Objection Letter – Planning Reference: 2020/60/93867/E

Proposal - Outline application for erection of residential development and formation of new access

Site - Land adjacent, Red Lea, 27, Church Lane, Mirfield, WF14 9HX

Church Lane, Mirfield - No. 21, 1985 & Church Lane, Mirfield - No. 18, 1989

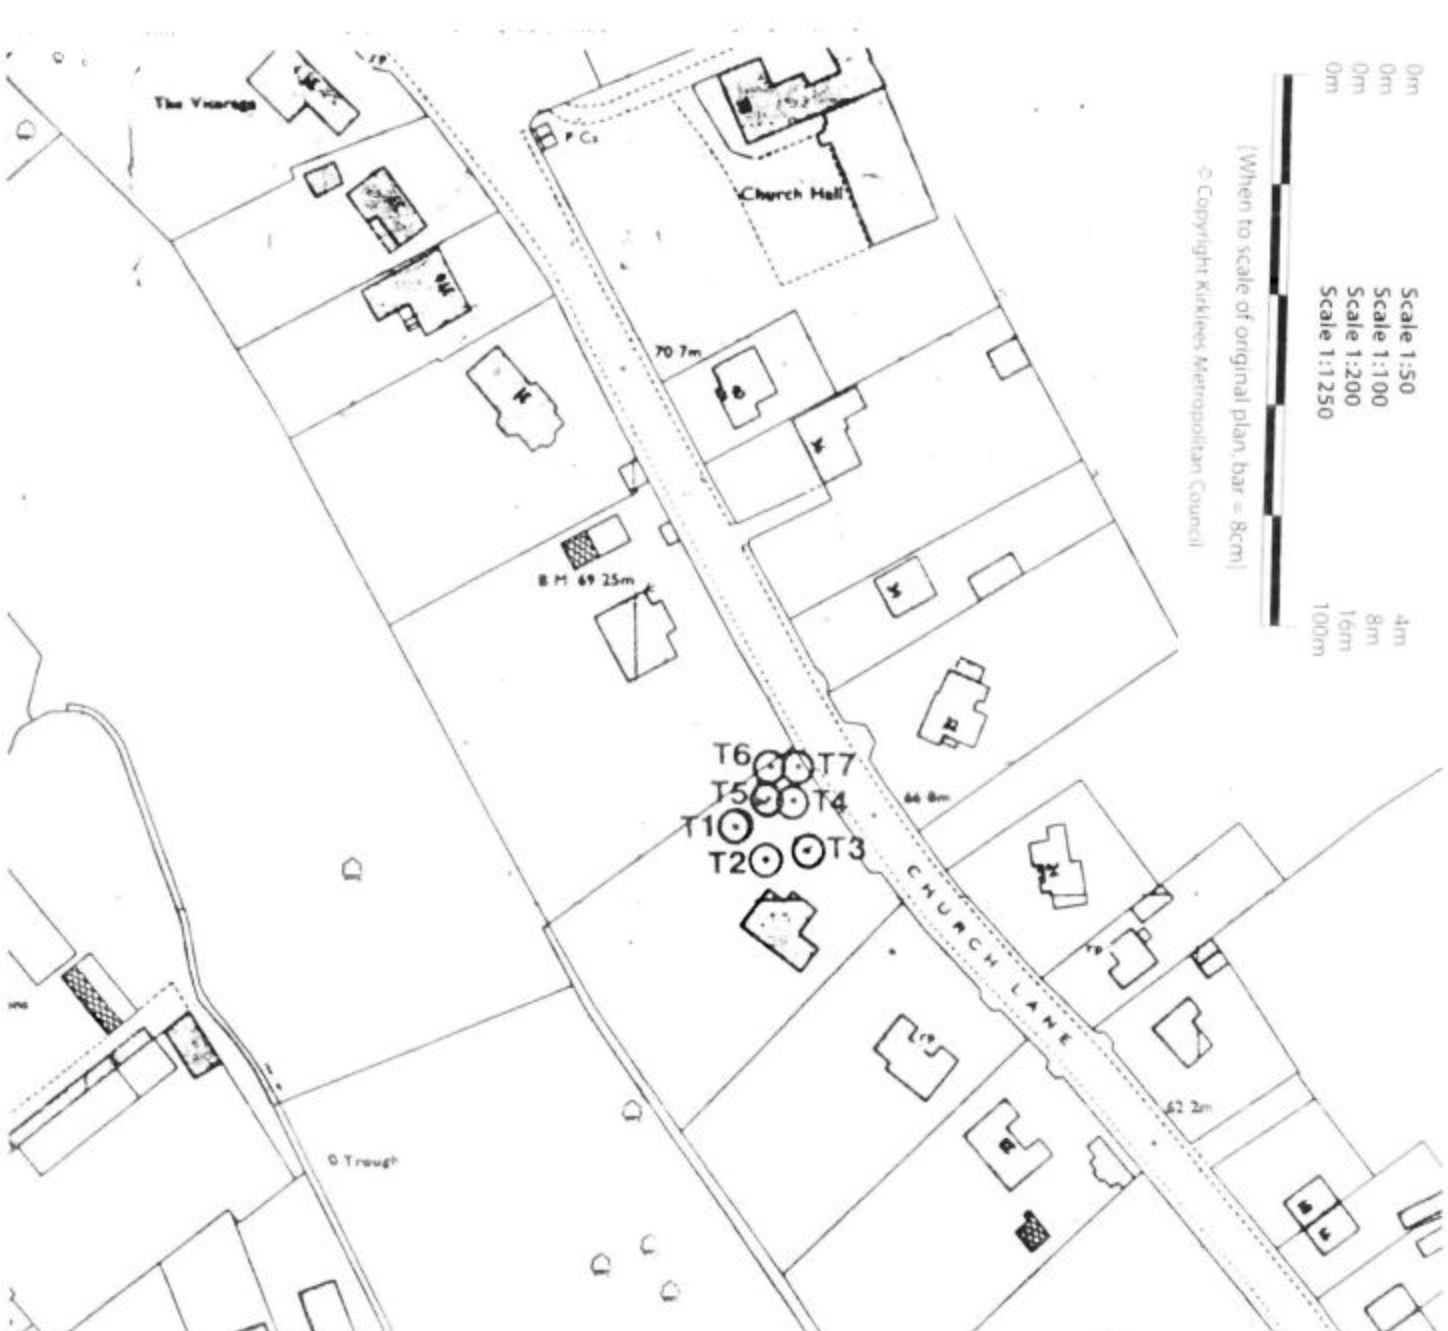
My clients' are particularly concerned about the impact on trees at the site that are of a high amenity value and covered by a Tree Preservation Order (TPO) as illustrated below.

The high level of tree loss required to facilitate the proposal cannot be supported. In addition, the siting of a dwelling at this location will result in pressures to fell or excessively prune the proposed retained trees over the long-term, due to conflicts between trees and future occupants.

No details have been provide on any shade patterns, however, it is clear that siting of a dwelling at this location will result in pressures to fell or excessively prune the proposed retained trees over the long term, due to conflicts between trees and future occupants. From the layout provided and taking into account the limitations of the plot, the proposed dwelling would have limited usable outside amenity space that is not dominated by tree issues, shade, seasonal nuisance etc, and the internal domestic areas and wider structure would also be impacted on by conflicts with the trees. Given this position if the Council approved this scheme they would find it difficult to resist any future tree work applications on trees covered by a TPO resulting from these conflicts. Consequently, the proposal would have a long-term and unacceptable impact on trees. Accordingly, the proposal is at odds with policies LP24 and LP33 of the Local Plan and the NPPF.

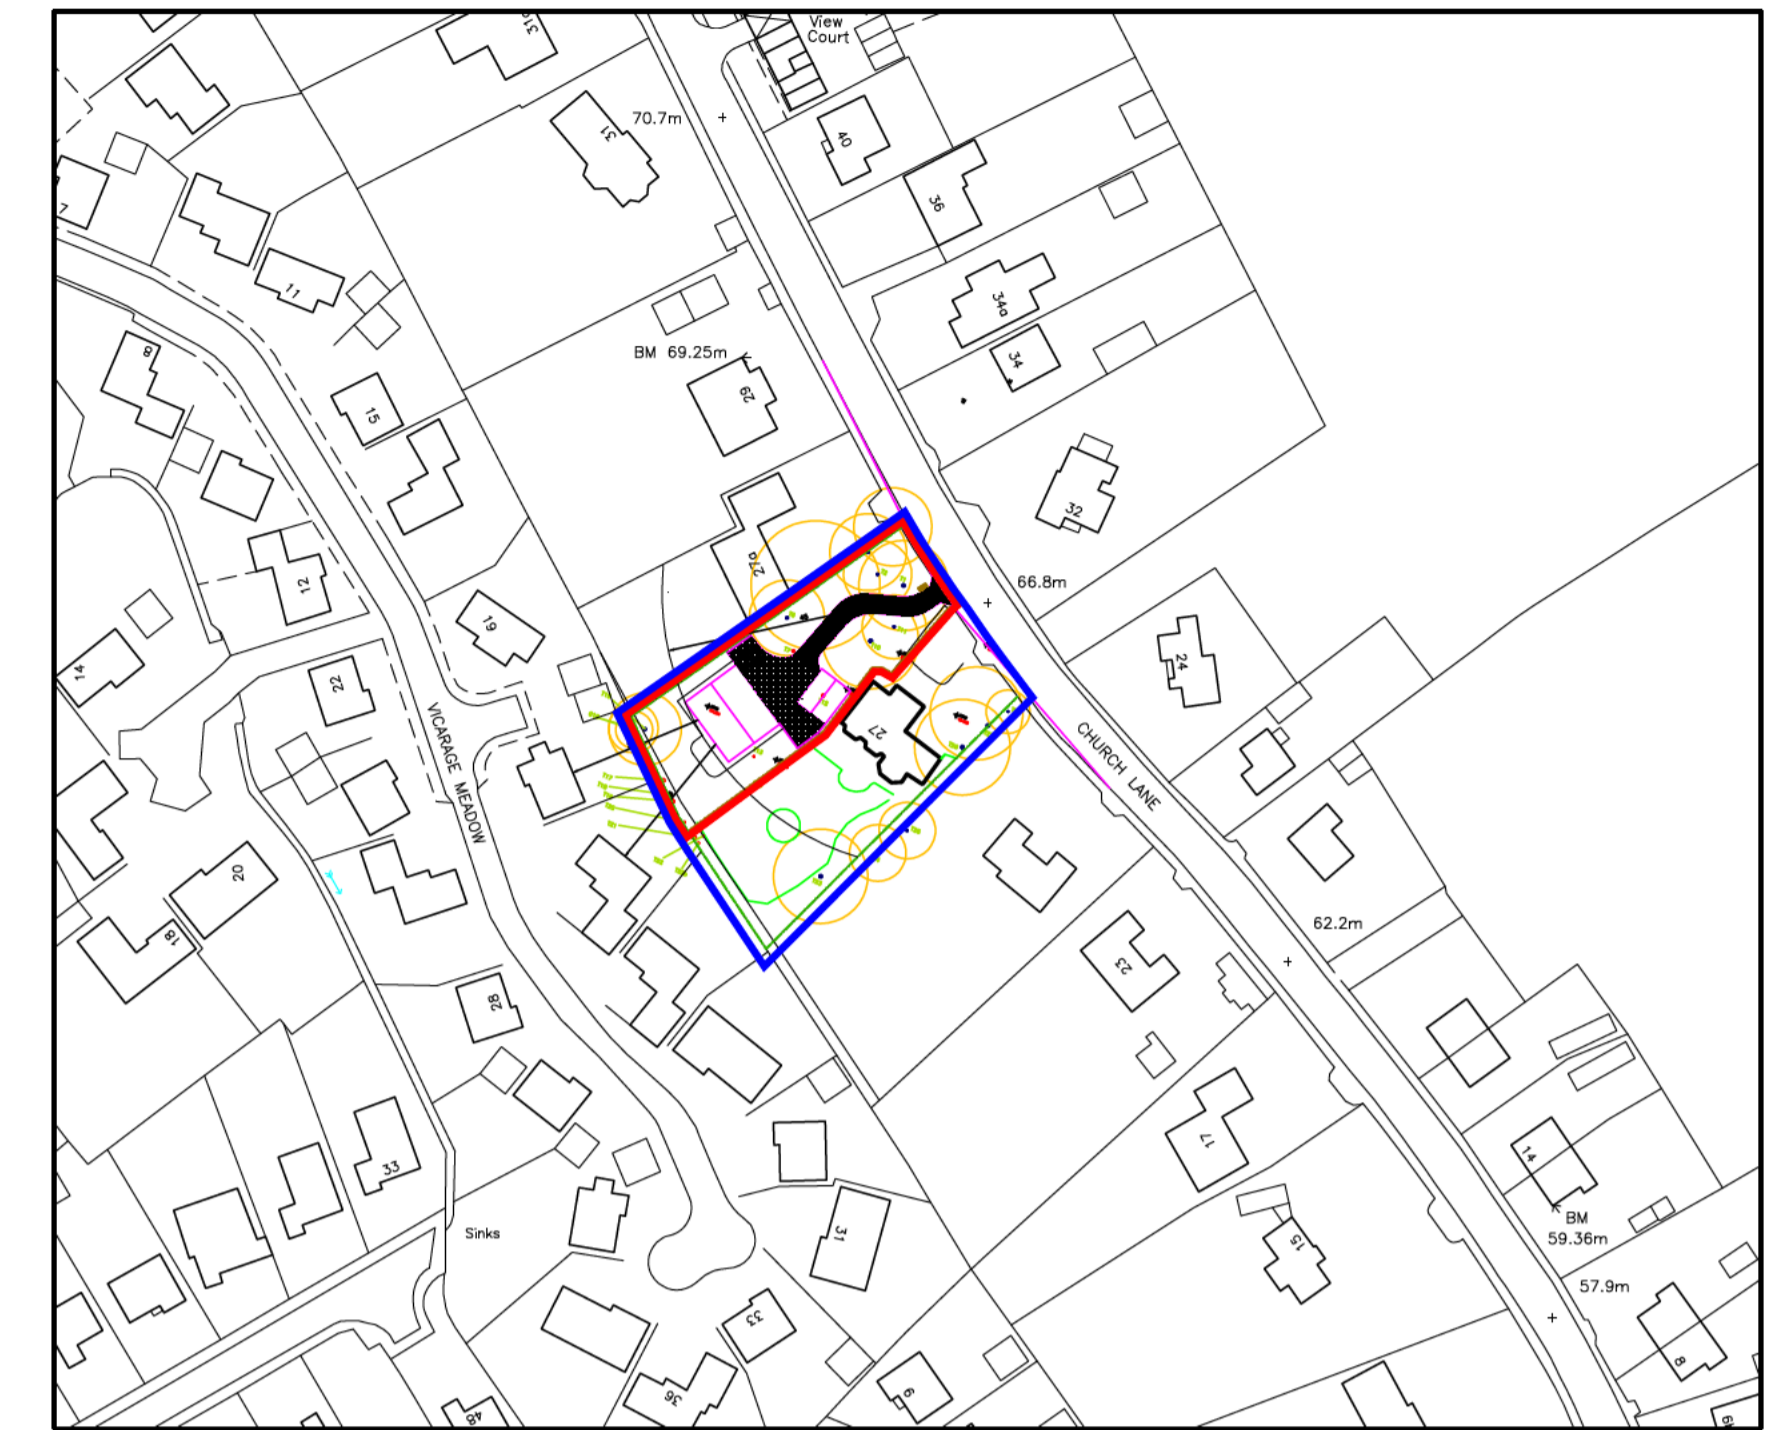
In addition, a parking area and tuning head is proposed adjacent to the boundary of No.27a. The intensification in use through increased vehicle movements including delivery vehicles will lead to an increase in noise and disturbance, that will have a detrimental impact on the use of my clients' private amenity space area where a degree of peace and quiet should be expected. Due to the proximity of the development to my clients' property it will inflict significant harm as a result of an increase in noise from vehicles, lights, as well as the opening and shutting of car

The proposed site plan is again ambiguous as it does not illustrate how cars can and delivery vehicles can access, park and turn safely within the site. No tracking plans or details of the access arrangements have been provided in respect of the requisite visibility splays that can be achieved on to the highway. It has not been demonstrated that suitable access to the development can be provided.
